Re: I-Joist Issues

Location: Lot 30 McKay Place (264 Hawksmoore Ln, Lillington, NC)
JDS Project No.: RDU2503308
Date of Inspection: 03/31/25

Crawl Space Plan 'F'
 SCALE: 1/4"=1'-0" AT 22"X34" LAYOUT 1/8"=1'-0" AT 11"X11" LAYOUT

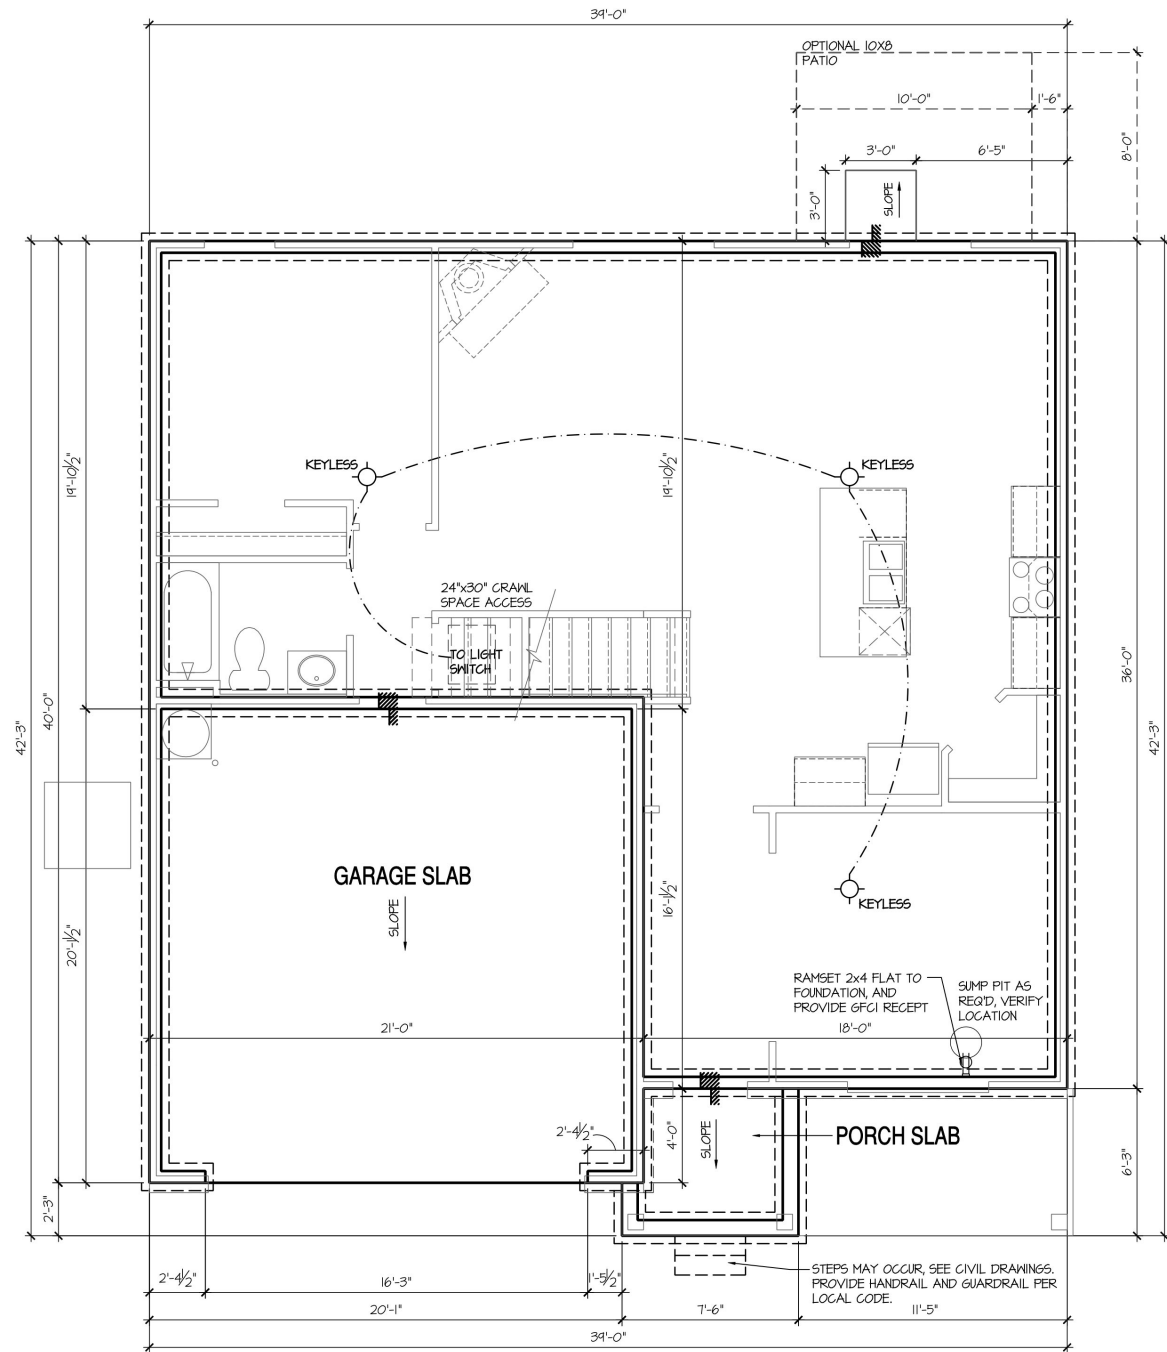
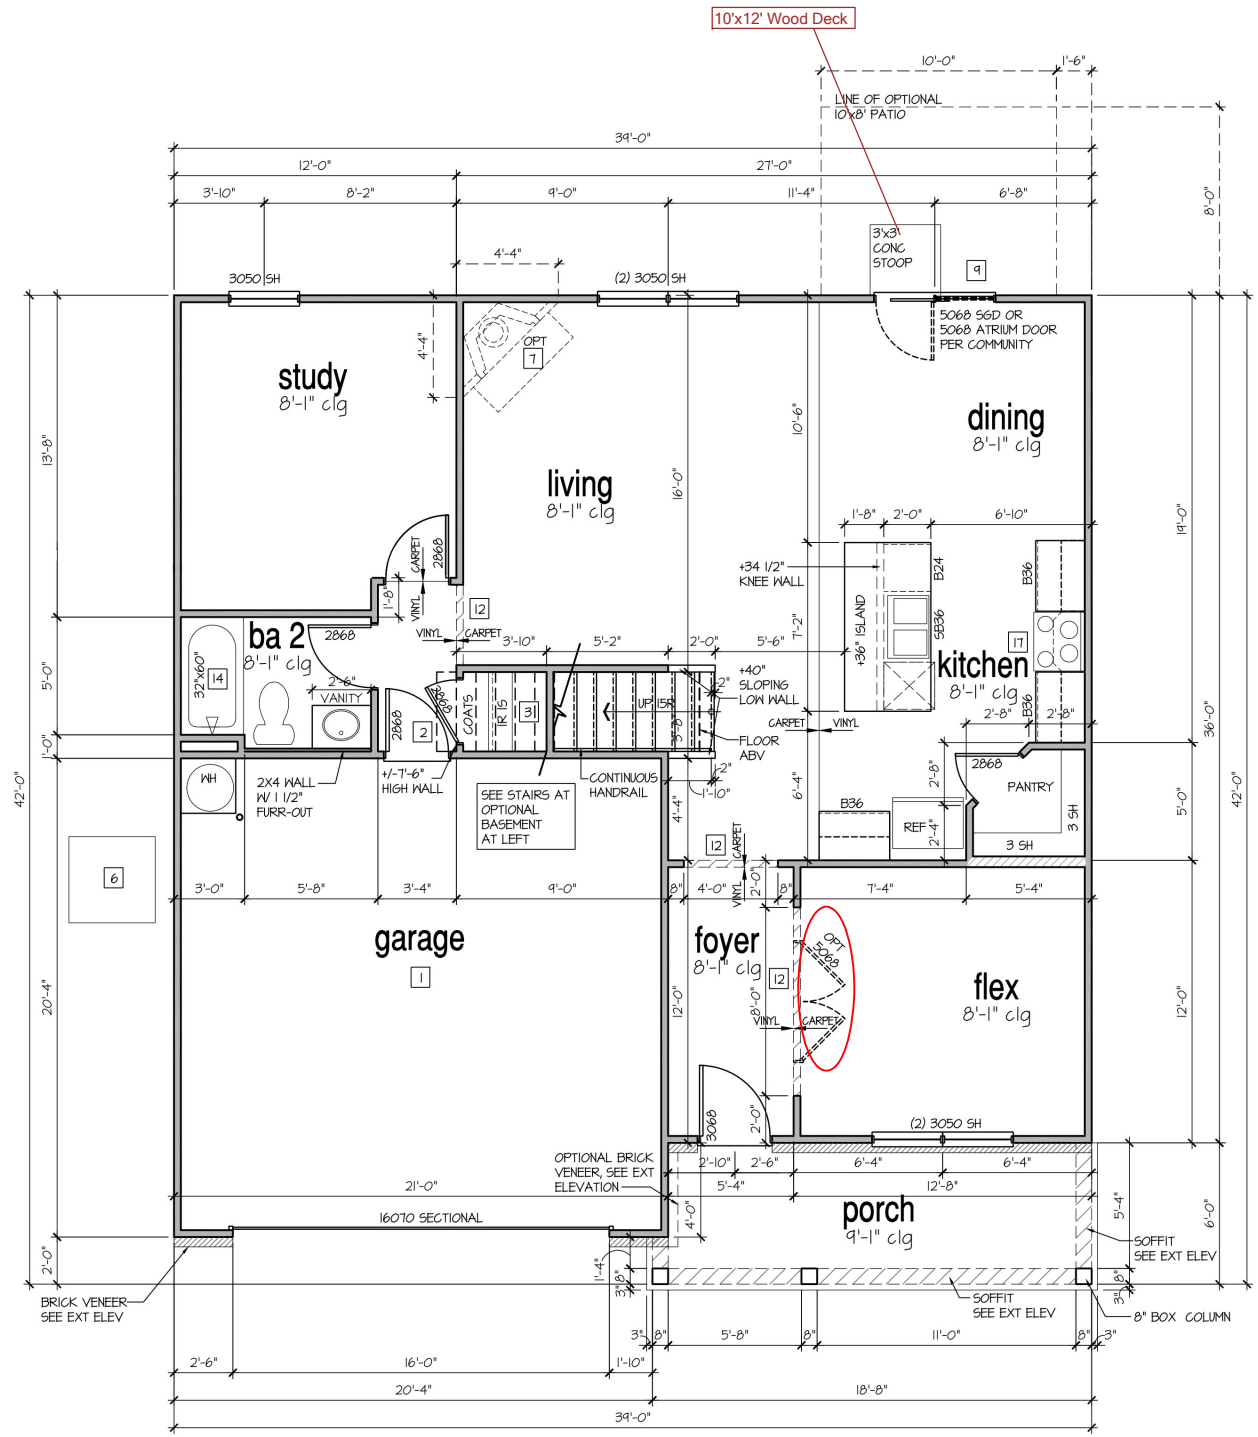
1. The 7th front to back I-joist (double) from the left exterior wall has a damaged bottom flange on the left face at the rear bearing wall.
2. The 13th I-joist from the rear exterior wall in the crawl space has top flange penetration due to plumbing pipe near the right bearing end.

1. Install a 4' by $\frac{3}{4}$ " OSB strip in the web starting from the bearing end tight against the bottom flange over the damaged flange attached with structural adhesive and (1) row of 6D nails spaced at 4" o.c. Then install a 4'2x4 scab flush with the bottom flange starting from the bearing end attached with (2) rows of 10D nails spaced at 4" o.c. with (1) row in the web and (1) row in the flange.
2. Install a 4' by $\frac{3}{4}$ " OSB strip in the web starting from the bearing end tight against the top flange on the opposite side of the damaged flange attached with structural adhesive and (1) row of 6D nails spaced at 4" o.c. Then install a 4'2x4 scab flush with the top flange starting from the bearing end on the opposite side of the damage attached with (2) rows of 10D nails spaced at 4" o.c. with (1) row in the web and (1) row in the flange.
